LSC Responses to EPC TIS Redline Comments

Eric S. Howard
Colorado Concrete Crushing

June 22, 2022
Transportation Memorandum

Colorado Concrete Crushing (LSC# S224330)

Figure 4

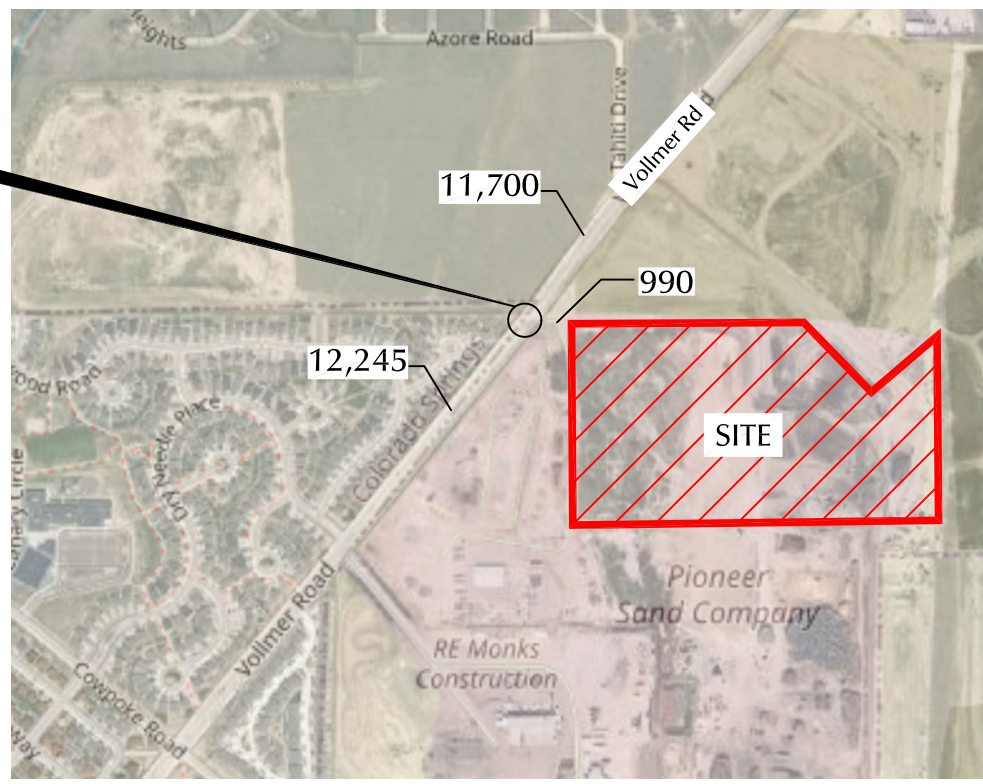
A left turn lane may be required based on the combination of existing and proposed traffic. If it only requires striping would it not be recommended?

LSC Response: The updated memo includes a recommendation that the current approved construction drawings be modified to provide a southbound left-turn lane.

Figure 2
Existing Traffic
Colorado Concrete Crushing (LSC# S224330)

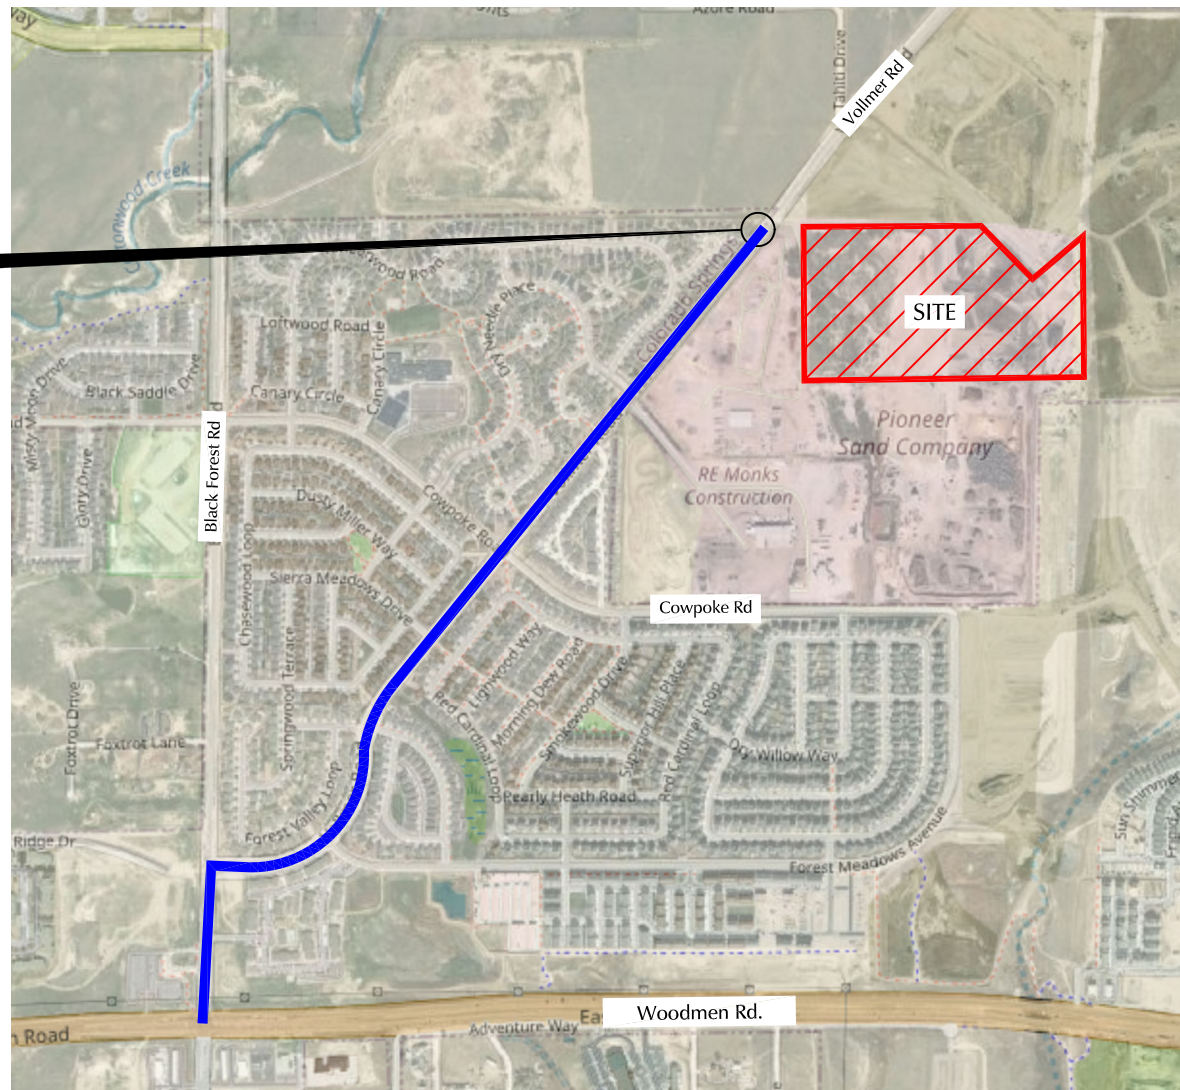
[Provide Link ADT](#)

LSC Response: The additional information has been included as requested.
